OBJECTION to application 2020/62/92400/W - overdevelopment of the plot

PROPOSED SITE PLAN 1:200
AFTER JUNCTION IMPROVEMENT WORKS 1:200

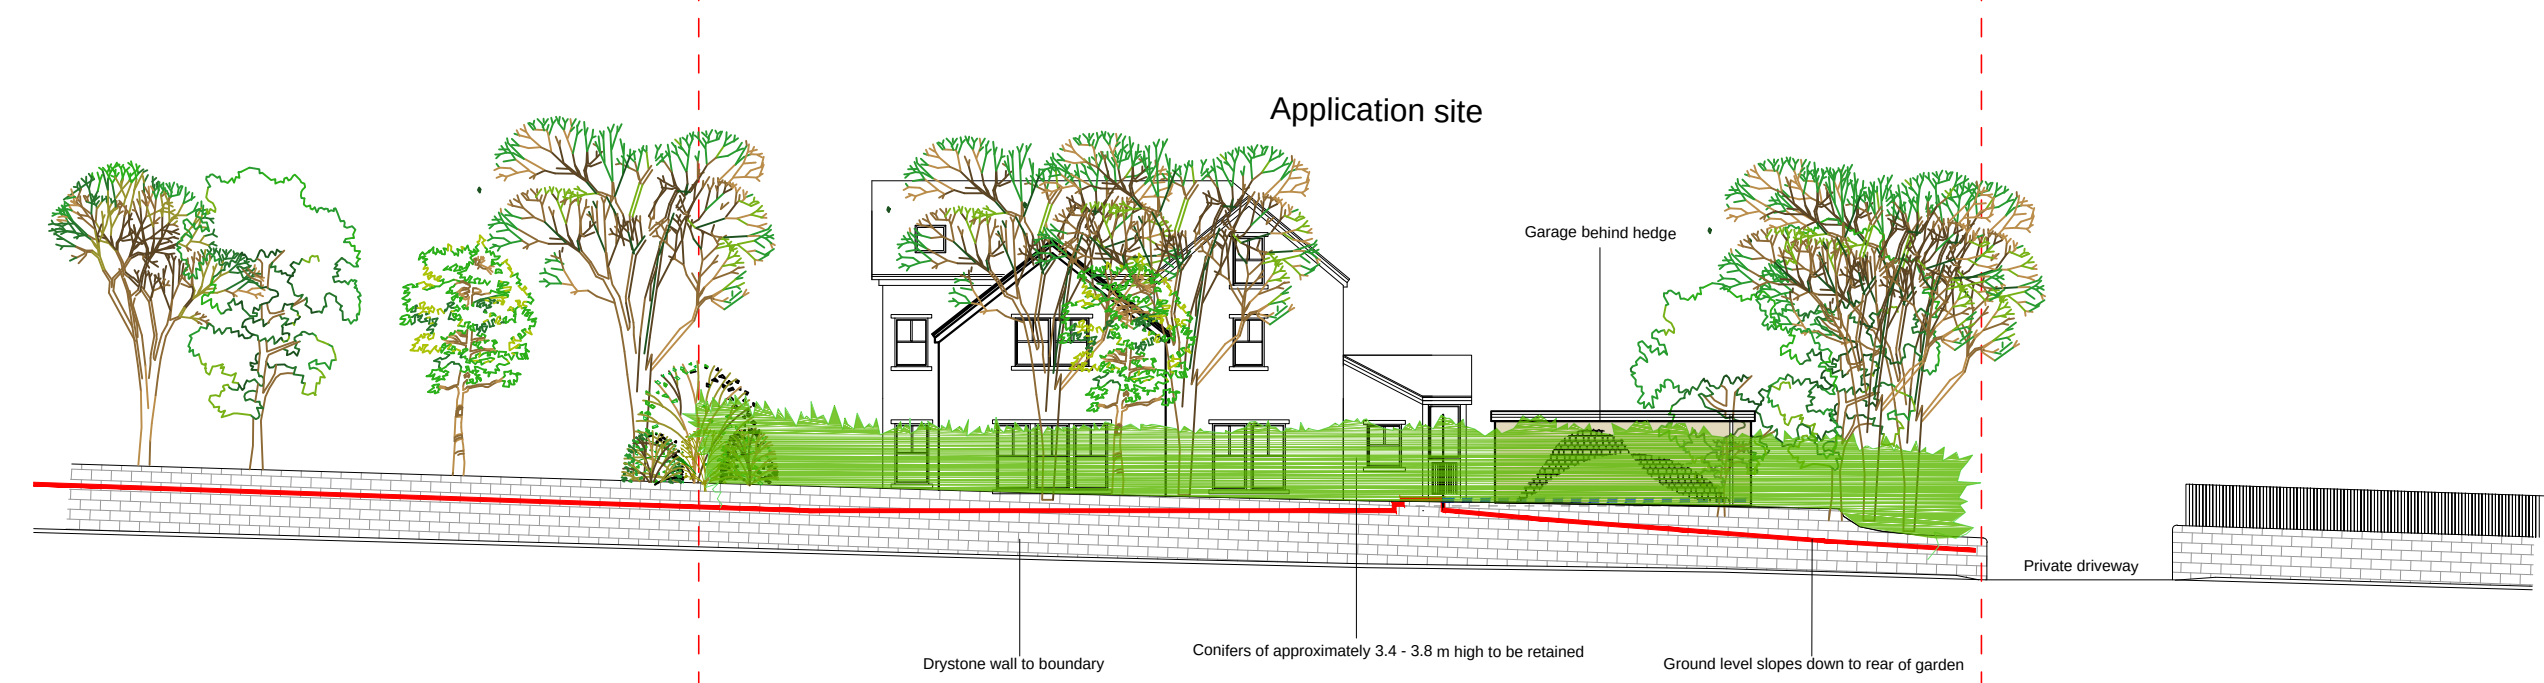
One reason for approving plans for this 6th house house to be built off a private drive (when Kirklees Highways directive was and still is, a maximum of 5 houses!!) was that it was to be set **well back** from the road -quoted from the then planning officer's notes. This detached garage would sit **well forward** of the host property

We now have a 4th application, again for a large double garage, now reduced in width by 1.9m but only by a mere 30cm reduced in height. It is in exactly the same position as the previously refused 3rd application, so all concerns and reasons for refusal from the Planning Inspectorate and Kirklees Planning are still totally relevant and must be applied to to this 4th application

This plot has already the highest building density compared to the other properties on the private drive - already at 21% with the two extensions, according to the Planning Inspector when approving them. The planned loss of 80 sqm from the plot for highway improvements will increase the building density even more.

To allow a double garage to be built would be yet another increase in the density and footprint.

The extensions built last year added 45.9 sqm and this garage would add yet another 43.56 sqm. Their combined total would be 89.46sqm which would be almost a 41% increase on the original building footprint of the site.

PROPOSED SITE SECTION (VIEW FROM BIRKBY ROAD) 1:200

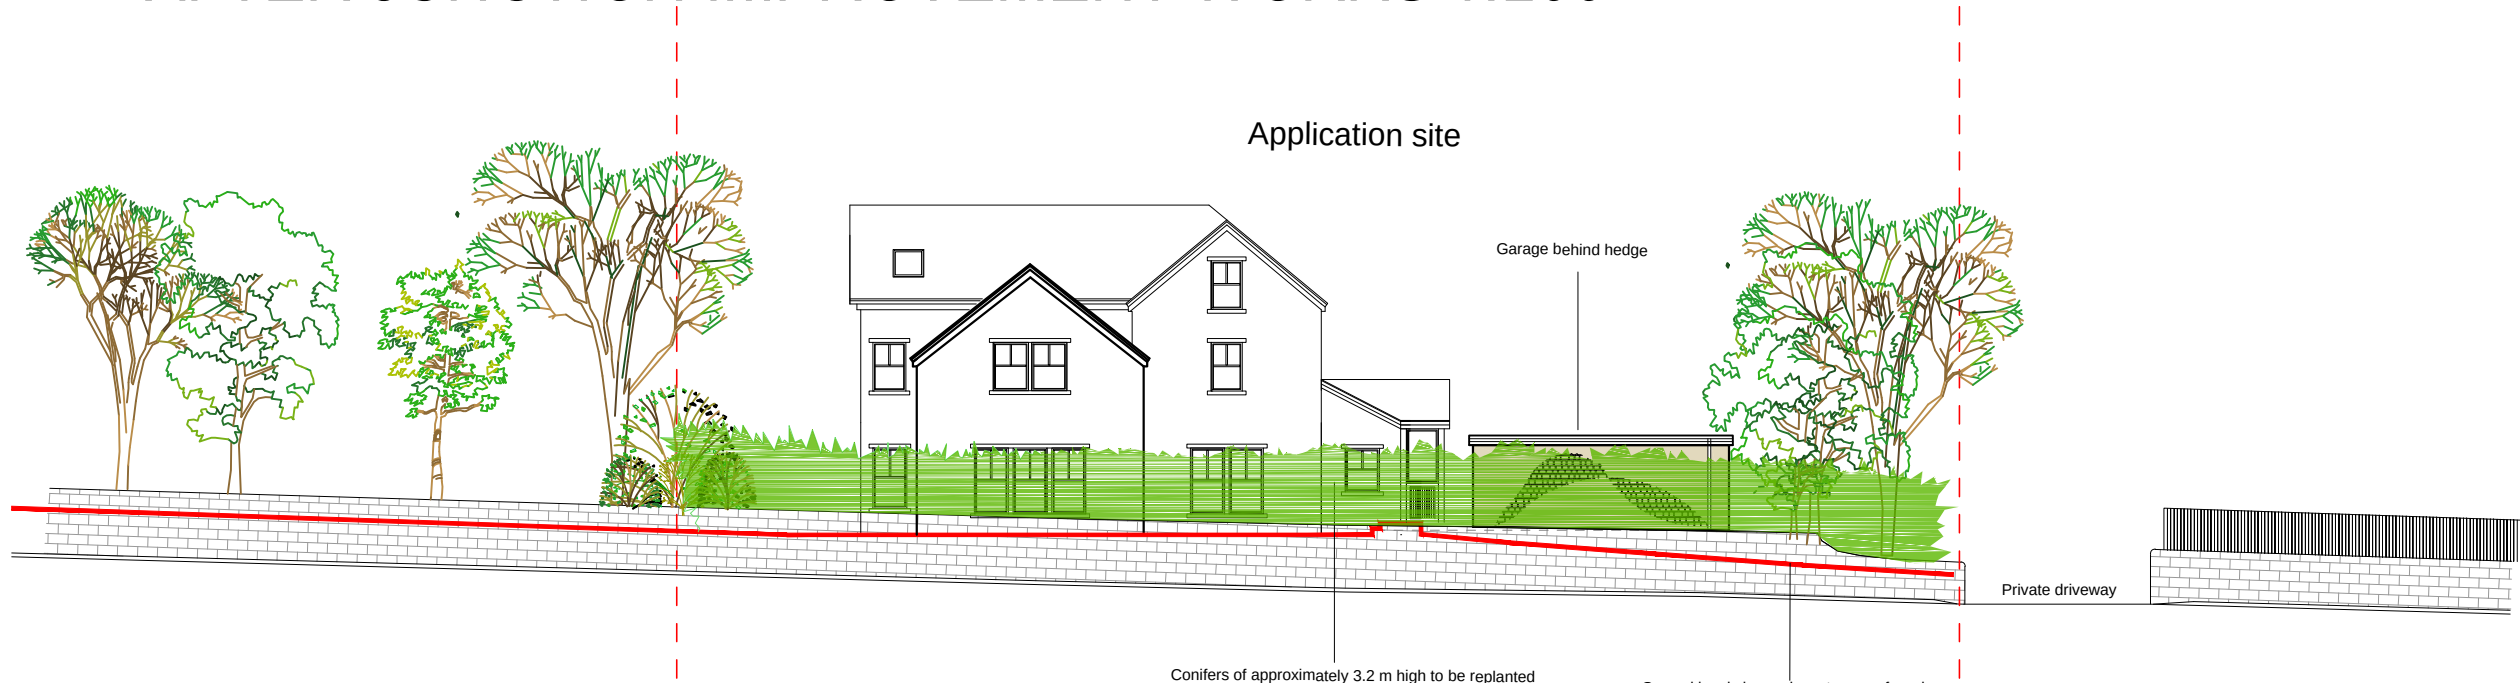
We urge the Planning Department to stand by their previous statements regarding overdevelopment of this site and refuse this application. The above must be taken into account alongside the misleading images in the plan and the negative effect on the visual amenity
